Arun District Council
Arun Civic Centre
Maltravers Road
Littlehampton
West Sussex BN17 5LF
Planning & Building Control General Enquiries
Tel: (01903) 737756 Fax: (01903) 730442
Dx: 57406 Littlehampton
Minicom: 01903 732765
e-mail: planning@arun.gov.uk
website: www.arun.gov.uk/planning

Application No: CM/17/21/PL
Site Address: Land at Wren Cottage Horsemere Green Lane Climping BN17 5QZ
Description of works: Development of 2 No. 2-bed & 2 No. 3-bed detached dwellings & associated works (resubmission following CM/53/20/PL). This site is in CIL Zone 3 & is CIL Liable as new dwellings.

Thank you for your internet representation made on 14th May 2021 which has been recorded as an objection with the comments as follows:

Drawing Title
Tree Retention and Protection Plan

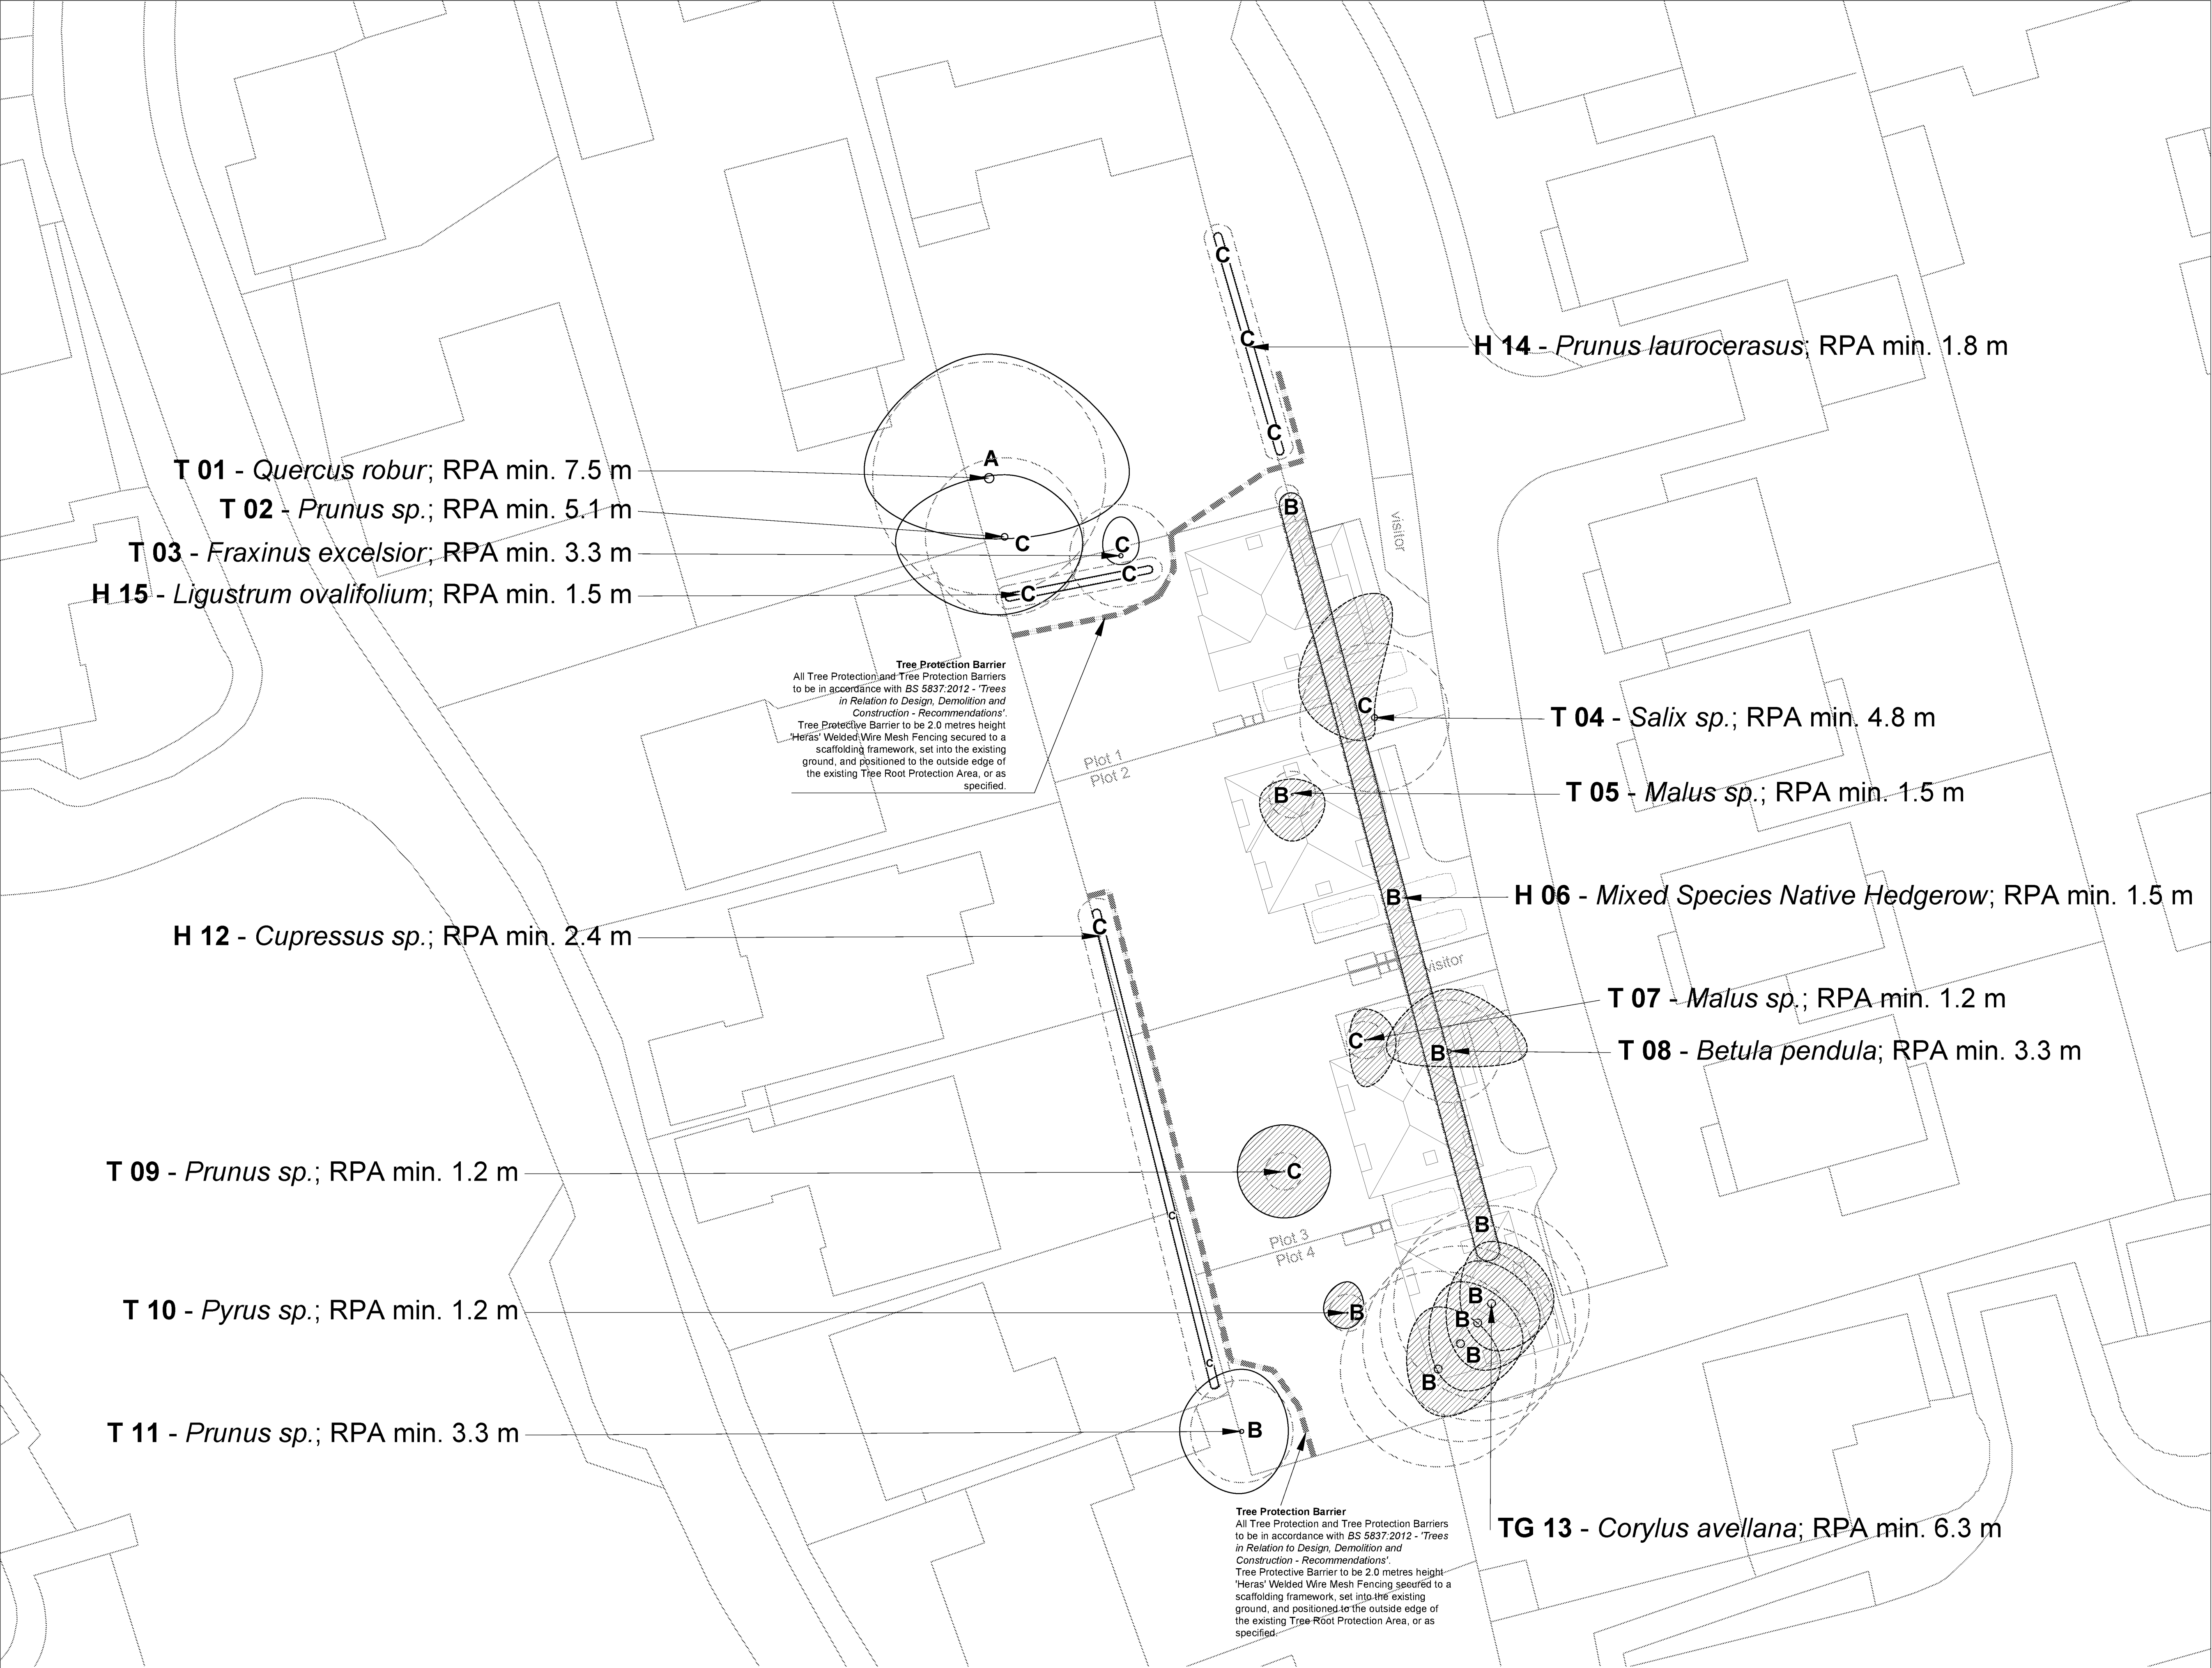
5. Council is concerned about the further loss of habitat for both flora and fauna. A full survey and assessment of the effect on displaced wildlife life and loss of vegetation and trees should be carried out.
